Recommendation Report for Planning Permission for Works or Extension to a Dwelling

REF NO: BN/24/18/HH

LOCATION: Sunray
Highground Lane
Barnham
PO22 0BS

PROPOSAL: First floor extension over garage, porch extension to front elevation to replace existing and single storey rear extension to replace existing.

Floor Plans

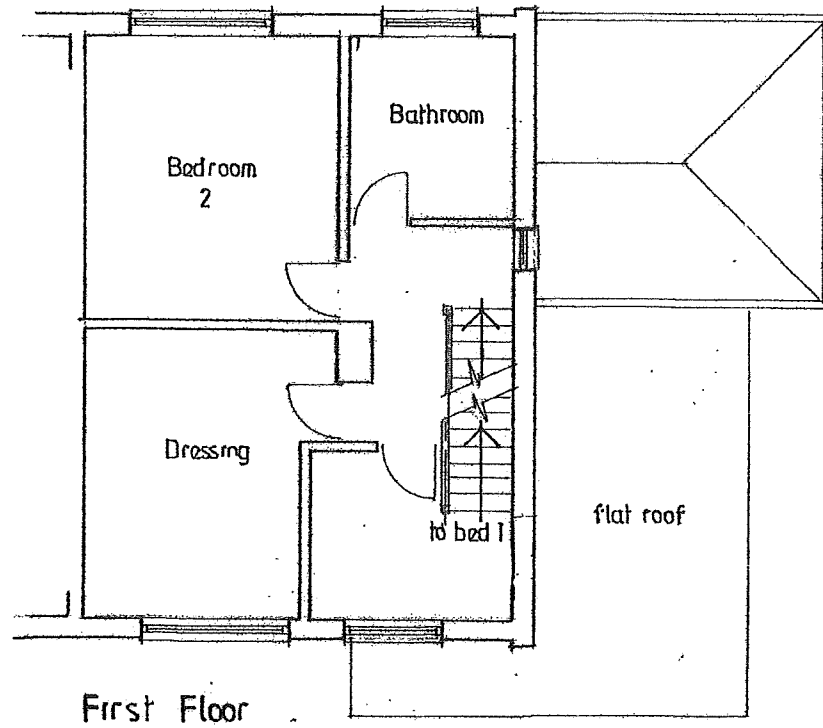
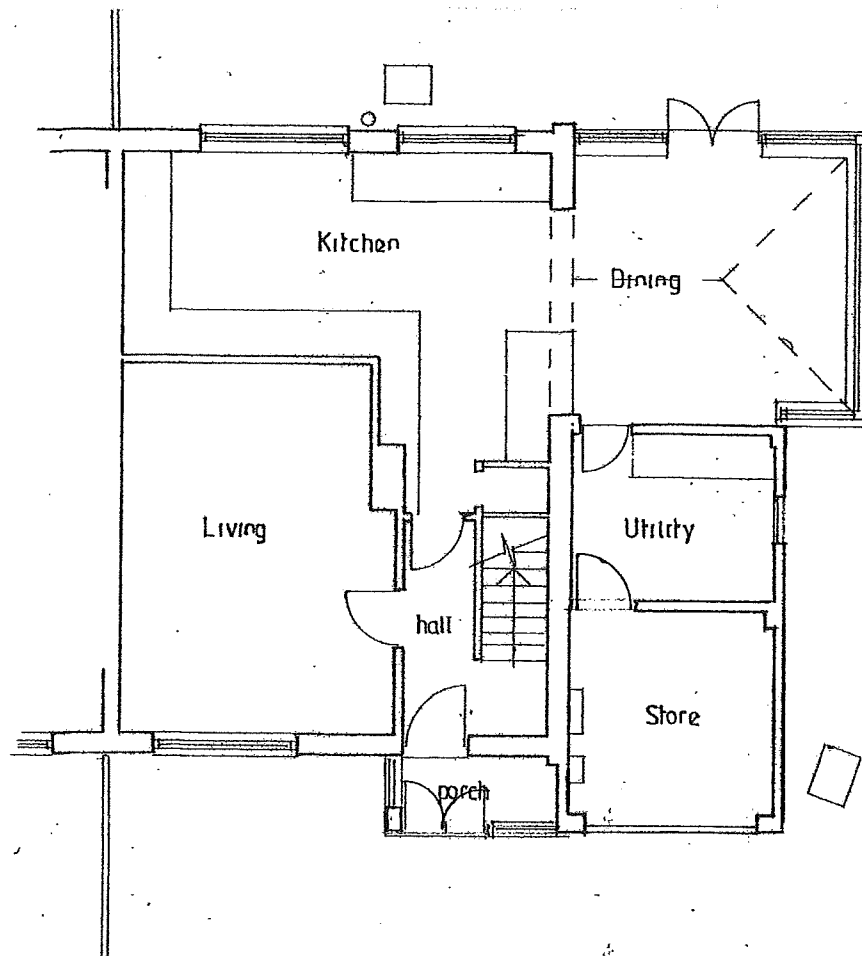
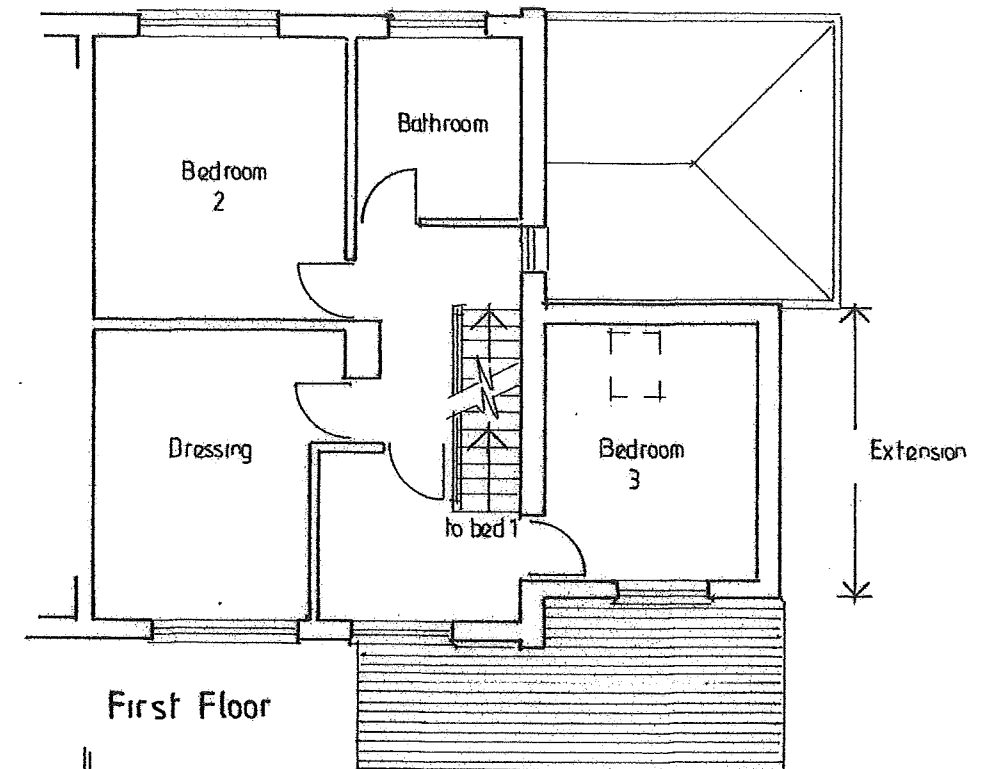
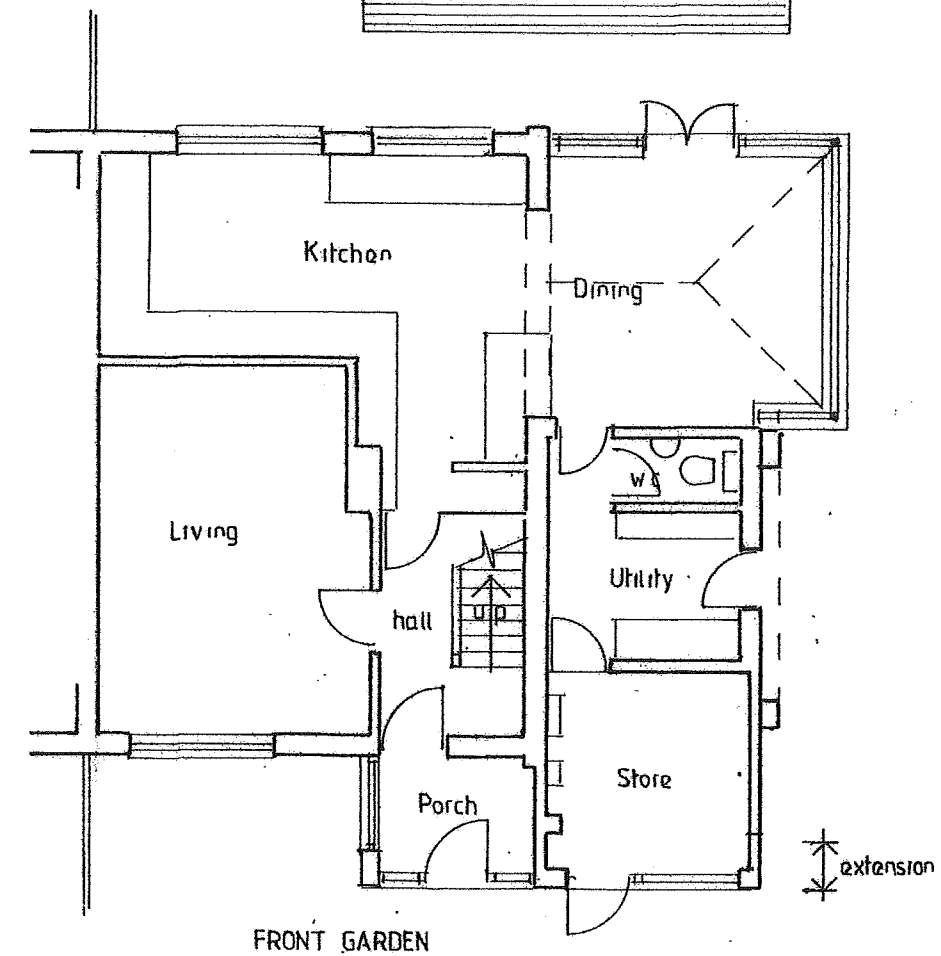
A first floor will also be created above an existing garage at the eastern elevation increasing the height by around 3.5m approximately 1.5m below the ridge height of the host dwelling and due to its design and siting is considered well integrated and subservient. Properties within the area are of a various design and style and therefore the proposed development is not considered out of character and the materials used will match that of the existing dwelling.

The first floor extension will have a depth of around 6.5m and sit 1.5m below the ridge height of the dwelling. There is one window proposed to the rear however it is not considered to give rise to any additional overlooking which exceeds that which is already possible.

There are no side windows proposed, however there will be an additional door to the eastern elevation although, due to its location and the boundary treatment, it is not considered to give rise to any unacceptable adverse impacts on neighbouring residential amenity.

Proposed
Elevations

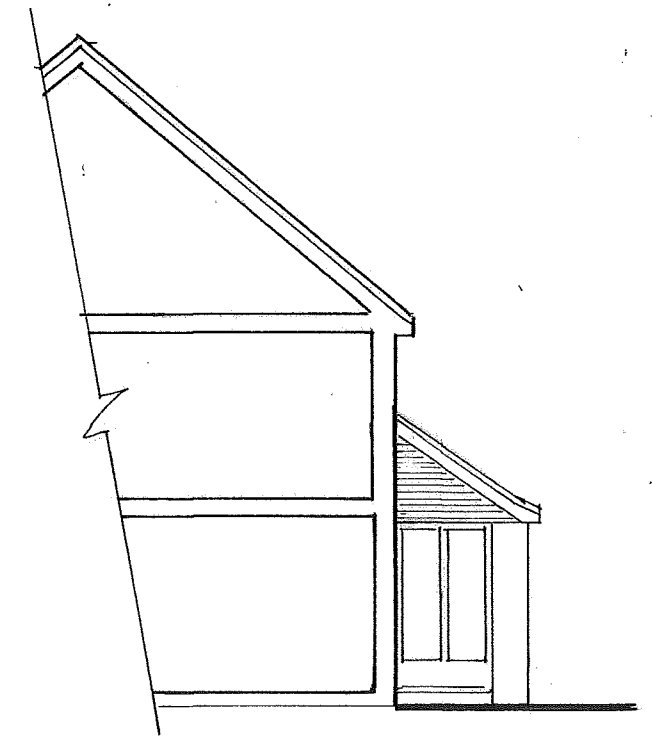
The existing porch already extends beyond the front elevation of the dwelling and the proposal will extend a further 1m, retaining around 6.5m to the front boundary. The height will also increase by around 1m with the construction of a lean to roof from a flat roof, however due to the design and location, the projection is not considered unduly dominant.

The porch will be extended 1m at the front elevation and the proposal will also replace an existing conservatory with a rear extension. It will have a height similar to existing at around 3.5m and there will be a 1m increase in depth to the rear which will extend 5m with a lean to roof. The extension to the rear and front of the property is modest in size and due to its location is not considered to be overbearing or give rise to any adverse overlooking impacts.
